KITTITAS COUNTY COMMUNITY DEVELOPMENT SERVICES

May 8, 2018

Subject: Evergreen Ridge (LP-18-00002) Final Plat – Staff Review and Request for Additional Information

EVERGREEN RIDGE P.U.D.-PARCEL B, DIVISION 2 PREPARED FOR TEANAWAY RIDGE LLC A PORTION OF THE NORTH 1/2 OF SECTION 12, TOWNSHIP 20 NORTH, RANGE 14 EAST, W.M. KITTITAS COUNTY WASHINGTON		
DWN BY D.L.P./G.W.	DATE 05/2018	JOB NO. 16079-1
CHKD BY D.L.P.	SCALE 1" = 100'	SHEET 1 OF 4

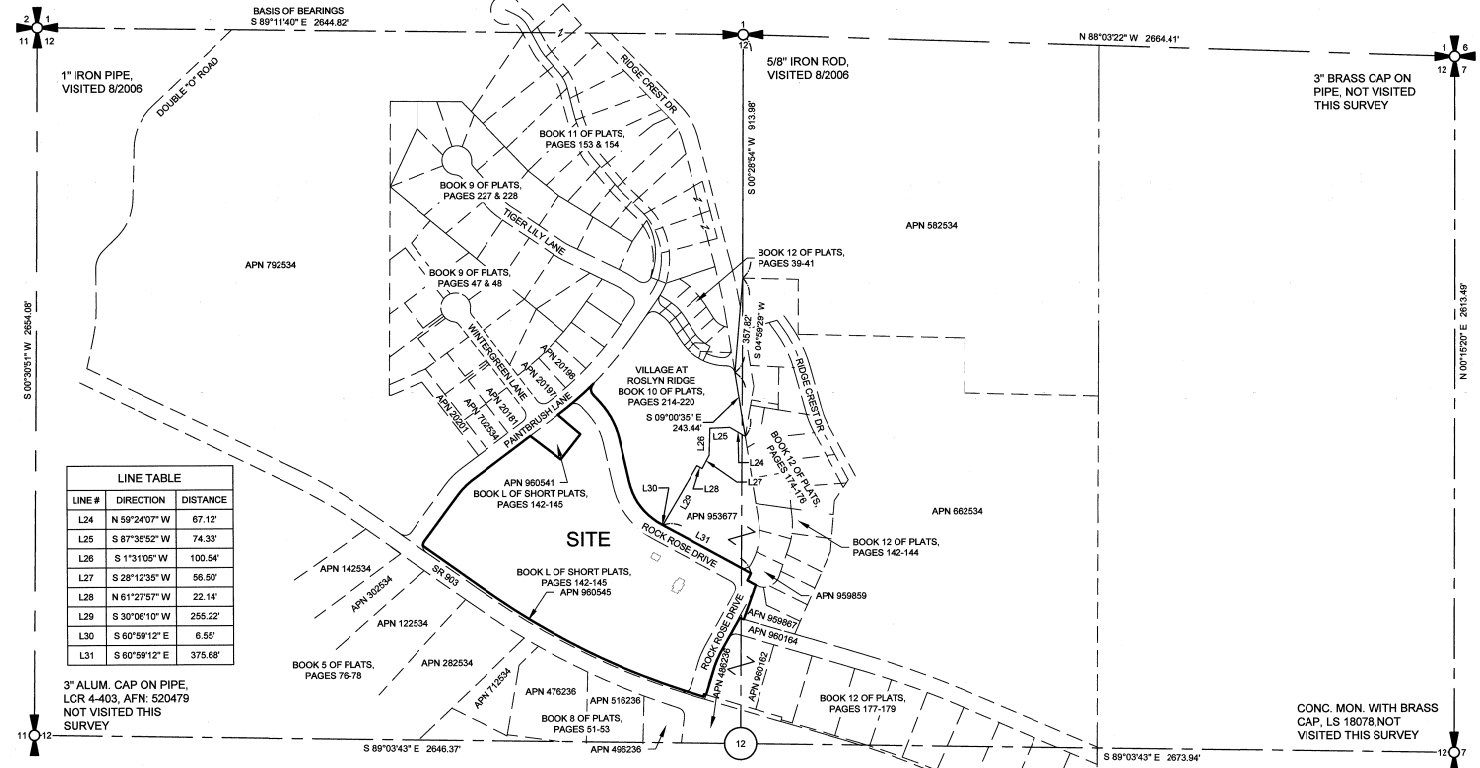
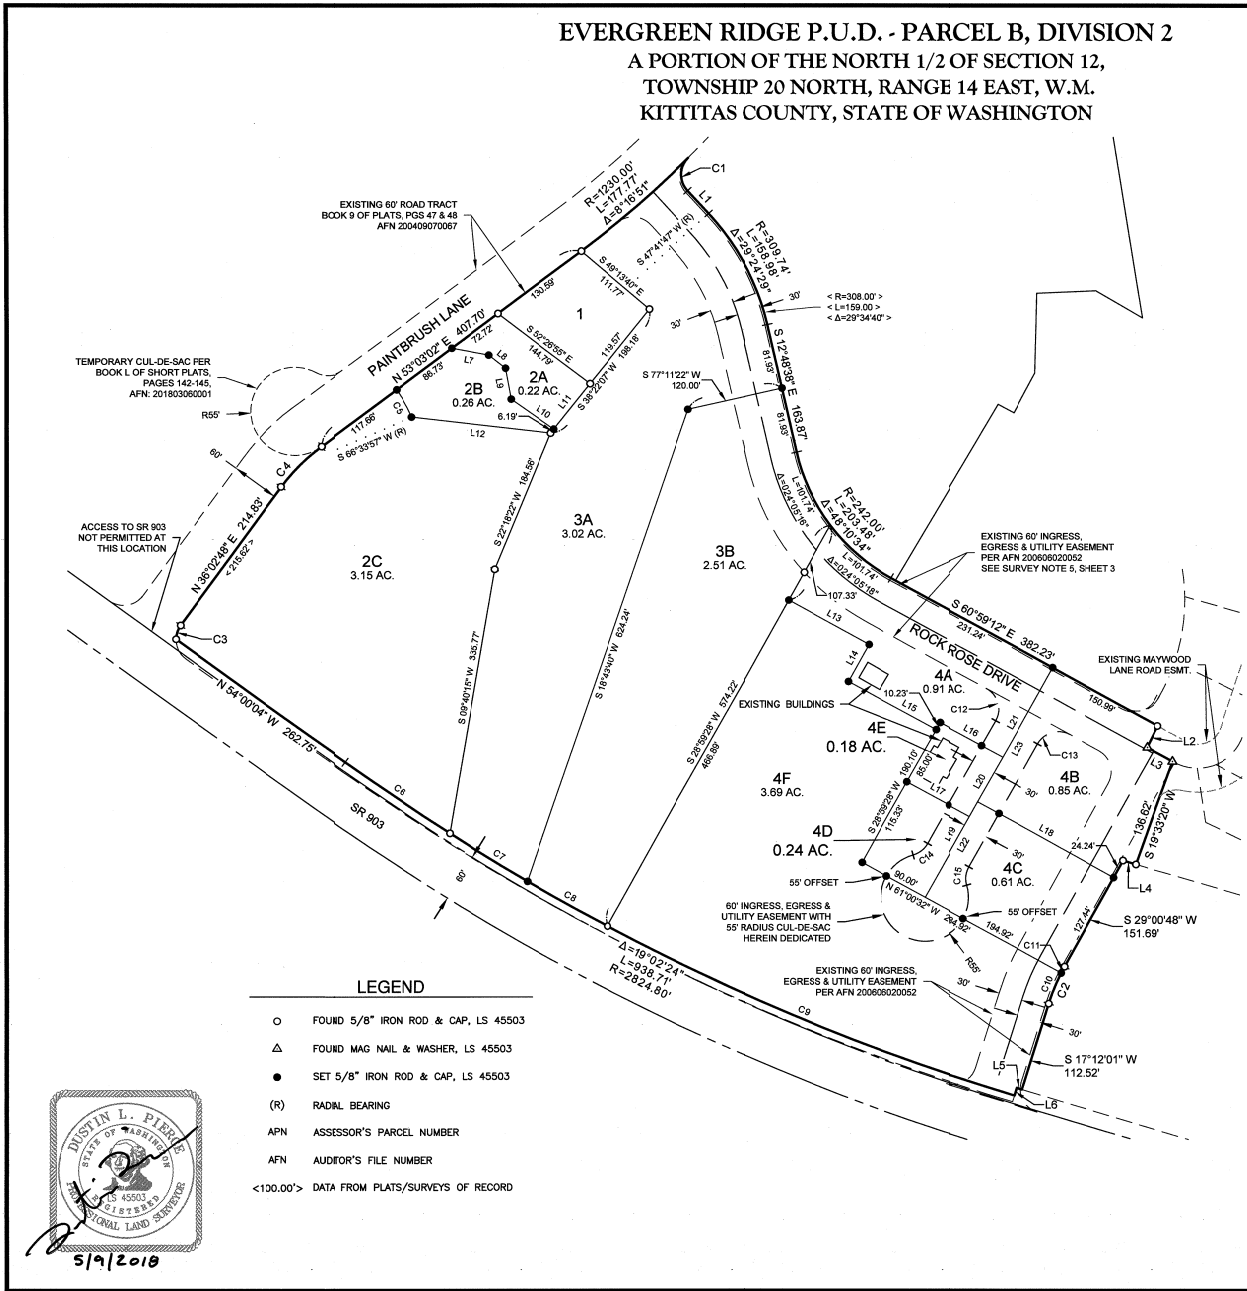
- Pursuant to the Evergreen Ridge Final Development Plan Amended Phasing Plan received April 6, 2016 and Resolution number 2016-072 approving the Evergreen Ridge Final Development Plan; three (3) plat notes must be shown on the final plat for parcels A,B,C,D,E,G, and H. Notes 1 and 2 are already provided upon the mylar, please add note 3 as listed below:

- Current year (2018) taxes must be paid in full. Please provide a copy of receipt from Kittitas County Treasurer's Office indicating payment.
- Please provide file numbers RZ-01-00010 and LPF-18-00002 in the upper right hand corner of each sheet of the final plat drawings.

- Required Changes
 1. A cul-de-sac is required on Paintbrush Lane and needs to be shown on the face of the plat, due to the roadway not having direct access onto SR 903.
 2. The connection of Paintbrush Lane onto SR 903 should show that it is for emergency access only, not a thru route.
 3. Show Maywood Lane Road Tract.

- **Required Changes**
 1. Include reference to survey documents that identify difference corner positions. Along the East line of Paintbrush

Lane as it compares to B:9, V:47
214.83' shown, 215.62 of record
Along the North line of Rock Rose Drive as it compares to V:10, B:214 and V:10, P:185 R=309.74' shown,
R=308.00 of record

2. Show Temporary Cul-de Sac on Paintbrush lane (per AFN:201803060001)
3. Show existing buildings on Lots 4A and 4E.
4. Include the Basis of bearing.
5. While not required for preliminary, the final submittal shall include dimensions of the curves of the access easement herein dedicated.
6. The plat notes include conflicting statements as to maintenance responsibilities for the access. Please correct. (Plat notes 5 and 8)
7. Please show the source of the file referenced in plat note 9.
